re: **Site Servicing Plan Review**
Proposed Multi-Storey Buildings
Greystone Village - Phase 3 - Scholastic Drive - Ottawa
to: Regional Group - Mr. Evan Garfinkel - egarfinkel@regionalgroup.com
date: June 6, 2022
file: PG5383-MEMO.03 Revision 1

Site Servicing Plan Review

- ☐ General Plan of Servicing - Greystone Village Phase 3 - Project No. 114025-PH3 - Drawing No. 114025-GP(PH3) - Revision 8, dated June 3, 2022.

CITY OF OTTAWA		PROJECT No.	
375 DESCHÂTELETS AVENUE		114025-PH3	
GREYSTONE VILLAGE PHASE 3		REV	
DRAWING NAME		REV # 12	
GENERAL PLAN OF SERVICING		DRAWING No.	
114025-GP/PH3

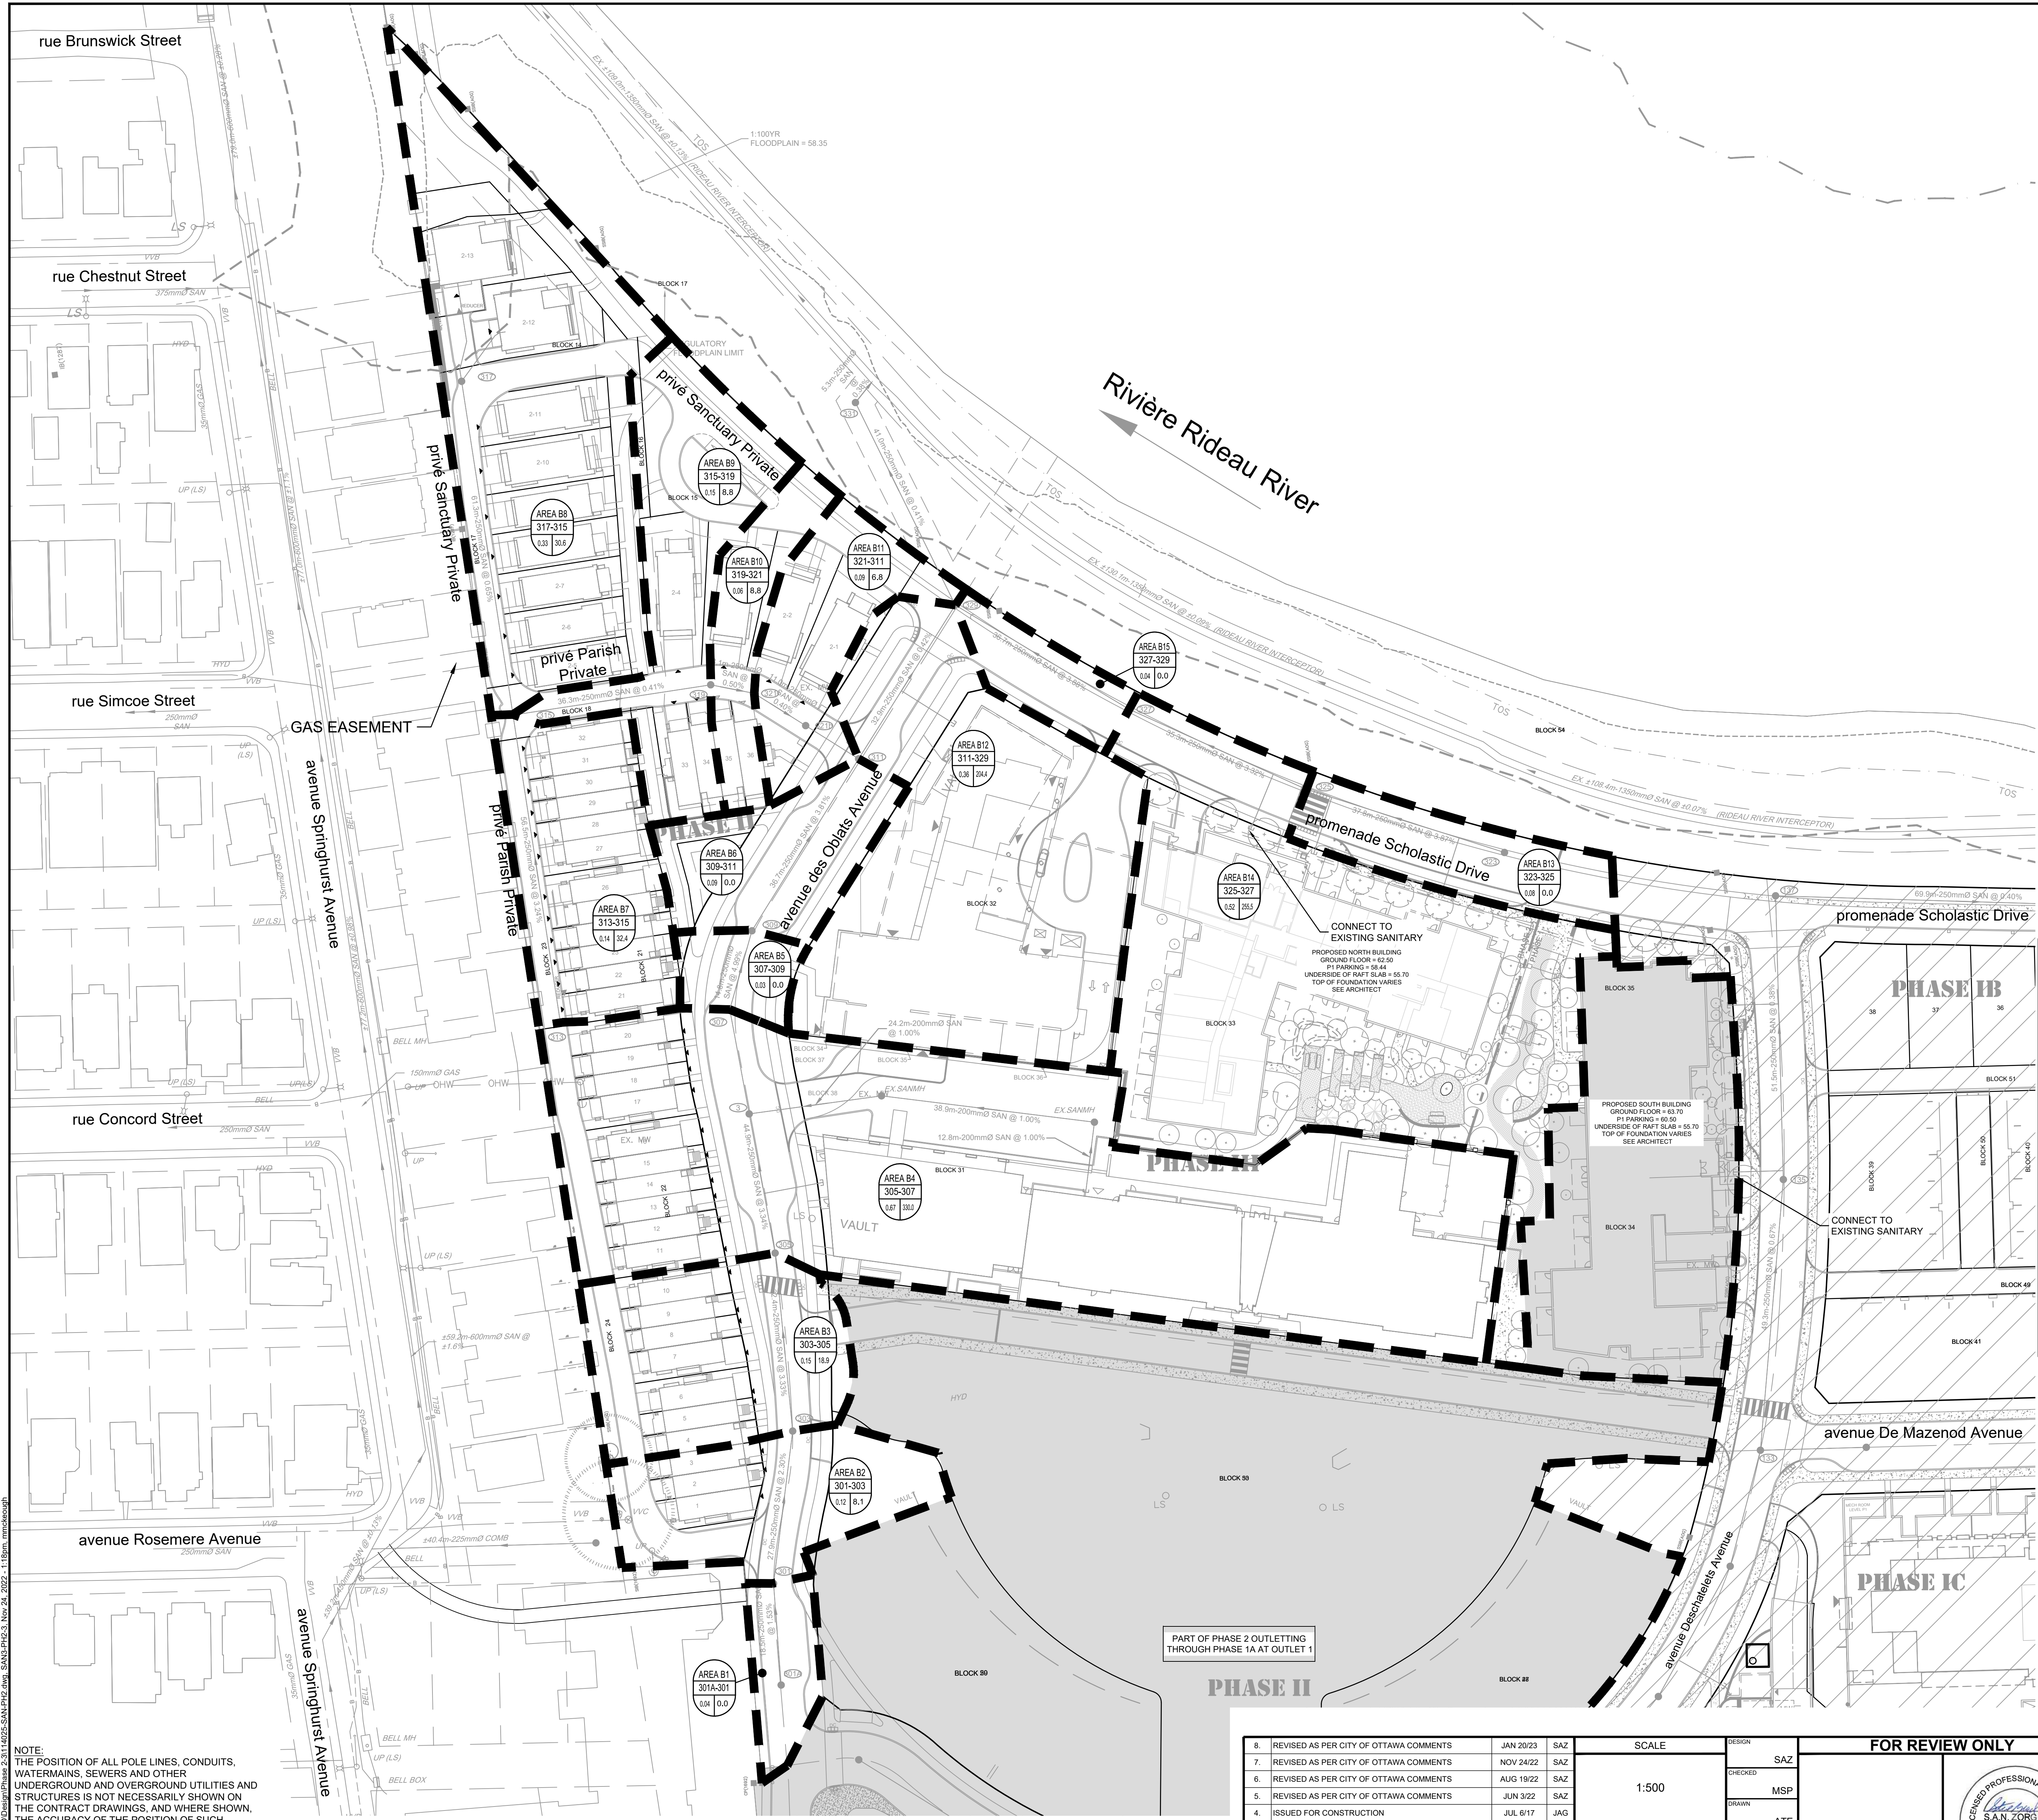
Based on our review of the site servicing plan, insufficient frost protection has been provided to sections of the storm and/or sanitary services which are noted to tie into the existing services located along Scholastic Drive and Deschatelets Avenue.

Specifically, the storm services located at the eastern portion of the site, tying into the services along Scholastic Drive, as well as the storm and sanitary services (invert elevation = 61.42 m) located within the southeast corner of the site and tying into the existing services along Deschatelets Avenue, will be founded within the frost zone (i.e. approximately 2.1 m below the finished grade). Refer to Figure 1, attached to the current memorandum, which illustrates these approximate locations. Frost protection of the site servicing is recommended where insufficient frost cover has been provided.

Any portion of the services installed at a depth of 2.1 m below finished grade or deeper is considered to have sufficient soil cover for frost protection. However, based on our review, the aforementioned sections of site servicing and their subgrades are anticipated to be founded within the frost zone. Where insufficient soil cover is present above the obvert of the pipe, the following frost protection criteria should be followed:

Table 1 - Rigid Insulation Recommendations for Sewer Pipes with Reduced Soil Cover			
Thermal Condition	Soil Cover Provided (mm)	Insulation Dimensions	
		Thickness (mm)	Extension (mm)
Unheated	1200 to 1500	50	Extend 900 mm horizontally beyond edge face of the sewer
	1500 to 1800	25	Extend 600 mm horizontally beyond edge face of the sewer
	1800 to <2100	25	Extend 300 mm horizontally beyond edge face of the sewer
Notes: All designs are based on a freezing index of 1000°C-days

Table 2 - Rigid Insulation Recommendations for Water Service Pipes with Reduced Soil Cover			
Water Pipe	Soil Cover Provided (mm)	Insulation Dimensions	
		Thickness (mm)	Extension (mm)
Watermain	2000 to <2100	50	Boxed or Extend 500 mm horizontally beyond edge face of the water pipe
		Pipe Insulation Details	
Water Service Laterals	1800 to <2100	150 mm thick Foamular XPS Pipe Insulation	
Notes: All designs are based on a freezing index of 1000°C-days

All rigid insulation should consist of either Dow Chemical High-Load 40 (HI-40), Styro Rail SR.P400, or equivalent approved by Paterson. The placement of all insulation within the service trenches must be reviewed and approved by Paterson personnel at the time of construction.
